My Ref: 28a Kingsway/315/20-1

12th December 2020

Ref: **Planning Applications: AW/315/20/T—OBJECTION.**
28a Kingsway, Craigweil

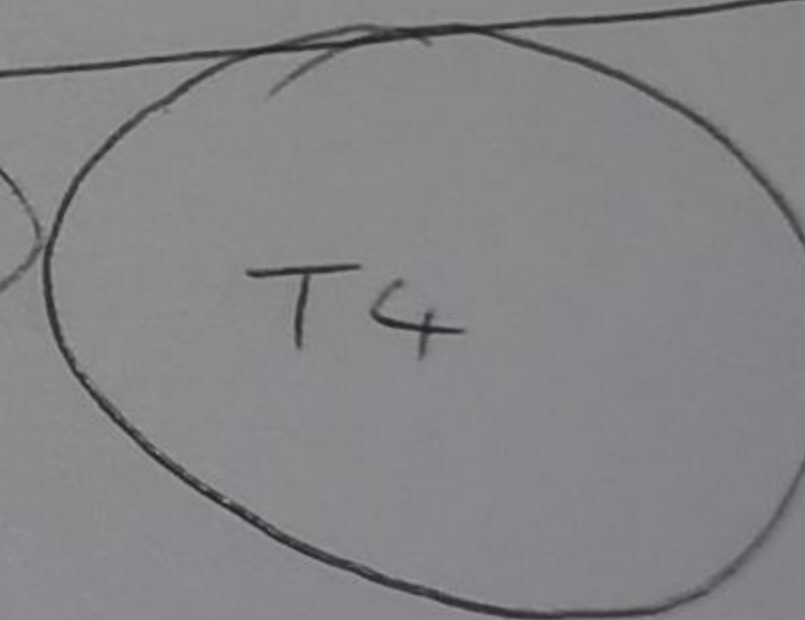
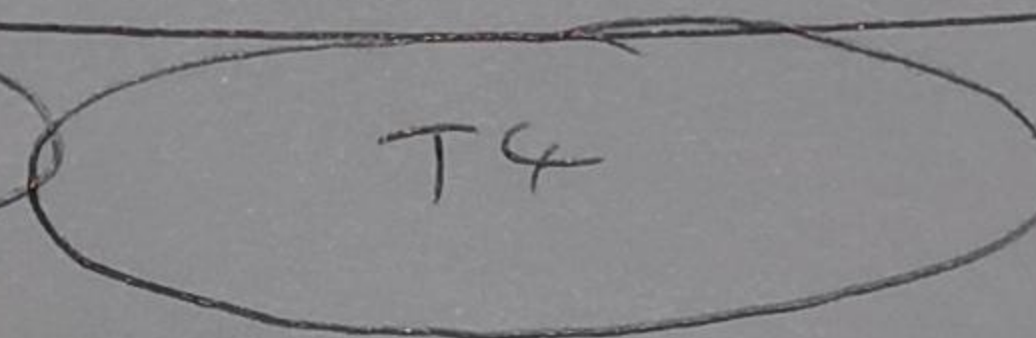
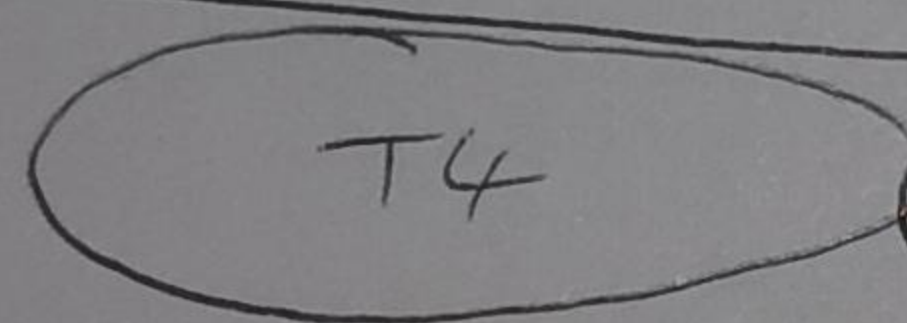
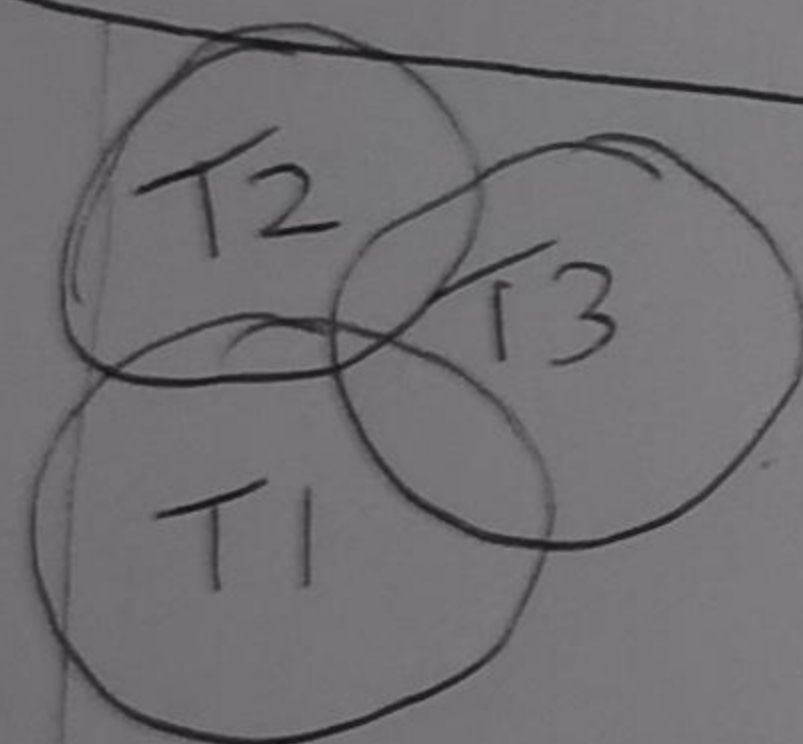
10. The description refers to the agent's own 'sketch', 'identifying' the trees/shrubs covered with "T" markers. **I do not believe this identification is sufficiently accurate** to pinpoint which individual trees/shrubs within this crowded border are involved in the proposed works. **The are no measurements nor distances shown.**
